TOWN AND COUNTRY PLANNING ACT 1990 FULL

Reference: H23-1157-19 **Date of Decision:** 20th April 2020
Applicant: Hortech Systems Ltd
Hall Gate
Holbeach
Spalding
Lincs
PE12 7LG
Location: Roslyn 36 High Road Whaplode Spalding
Description: Temporary siting of 3 storage containers (retrospective)

BLOCK PLAN 1:500

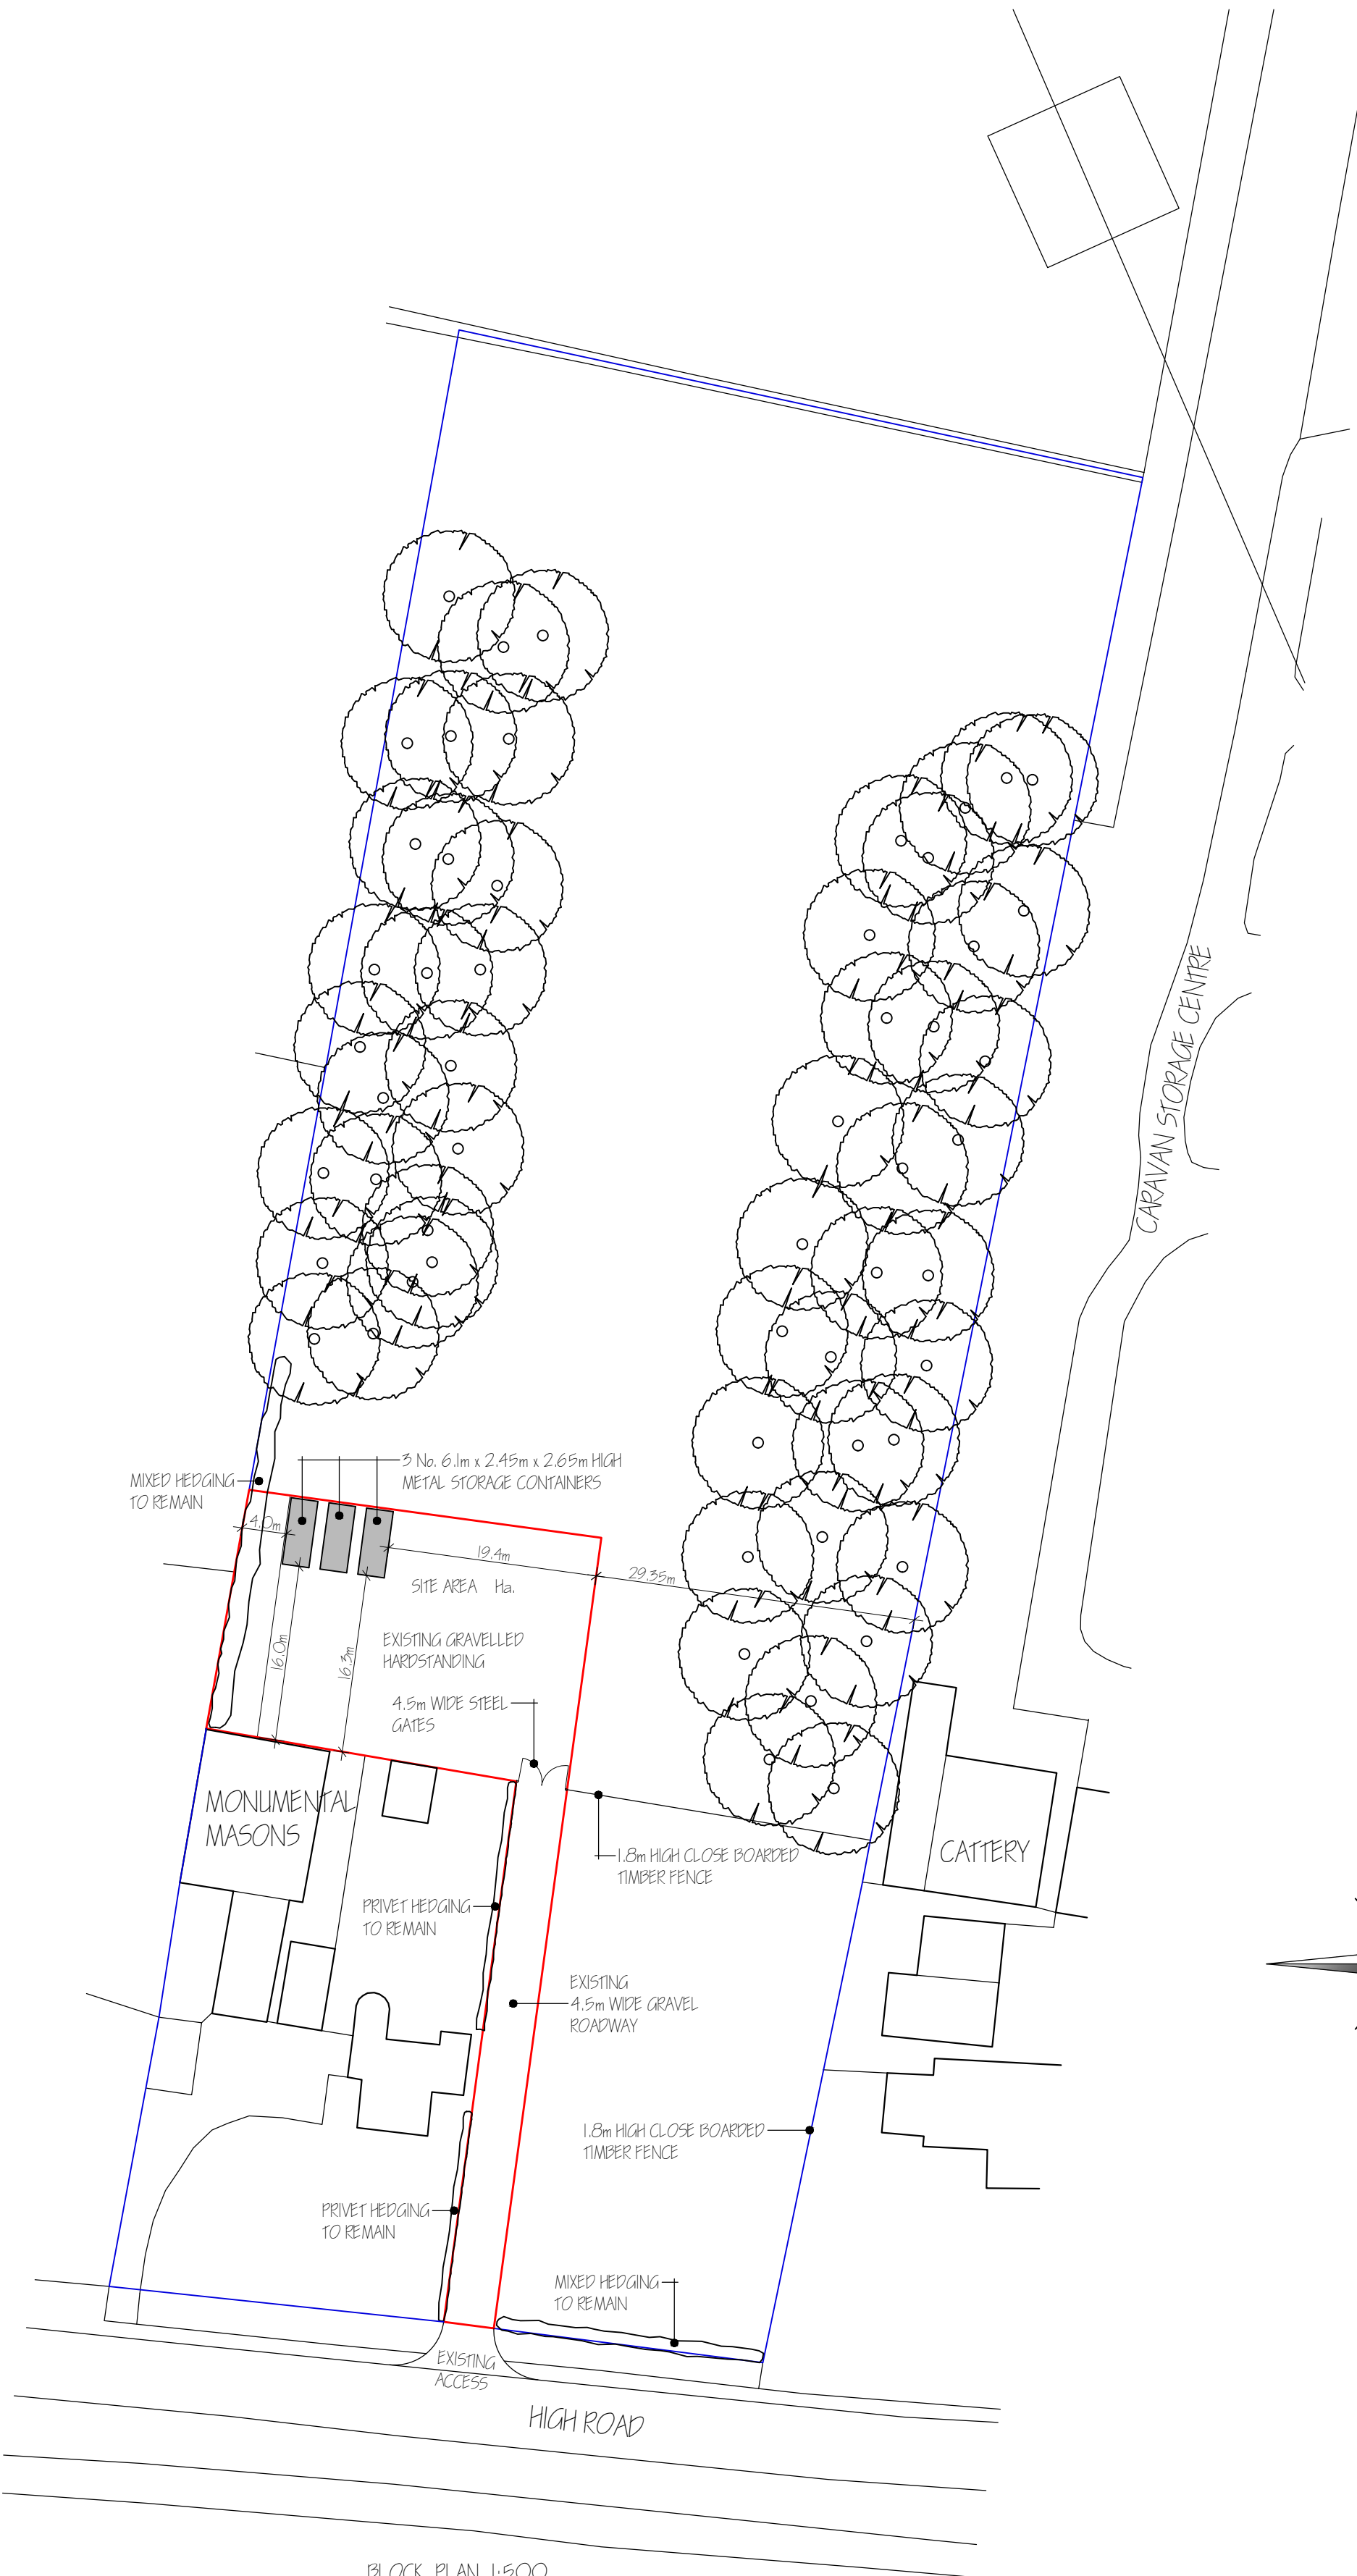
No evidence has been provided that the siting of storage containers is essential in this location.

Furthermore, the change of use of the land and the overall resulting appearance is at odds with its rural setting. It is not considered that any economic or community benefits would outweigh this environmental harm, and particularly when it has not been demonstrated why such a use cannot be accommodated within a defined settlement boundary.

No evidence has been provided to demonstrate that the storage units could be located elsewhere reusing previously-developed land or converting/re-using redundant buildings. Therefore, the proposal must comply with the criteria listed above, however it is considered that it fails against some of these. The change of land use from agricultural to B8 is not responsive to the local context (criteria c) dominated by open agricultural fields and some residential properties in the immediacy of the site. Likewise, the B8 use of the land will constitute a significant adverse impact upon the character and appearance of the area (criteria b) and the intended storage operations could well conflict with neighbouring land uses (criteria a).

The site is therefore not considered to be a suitable site for the proposed development with particular regards to the impact upon the character of the local area and neighbouring land uses. The proposal is therefore contrary to Policy 7 of the South East Lincolnshire Local Plan (2019).
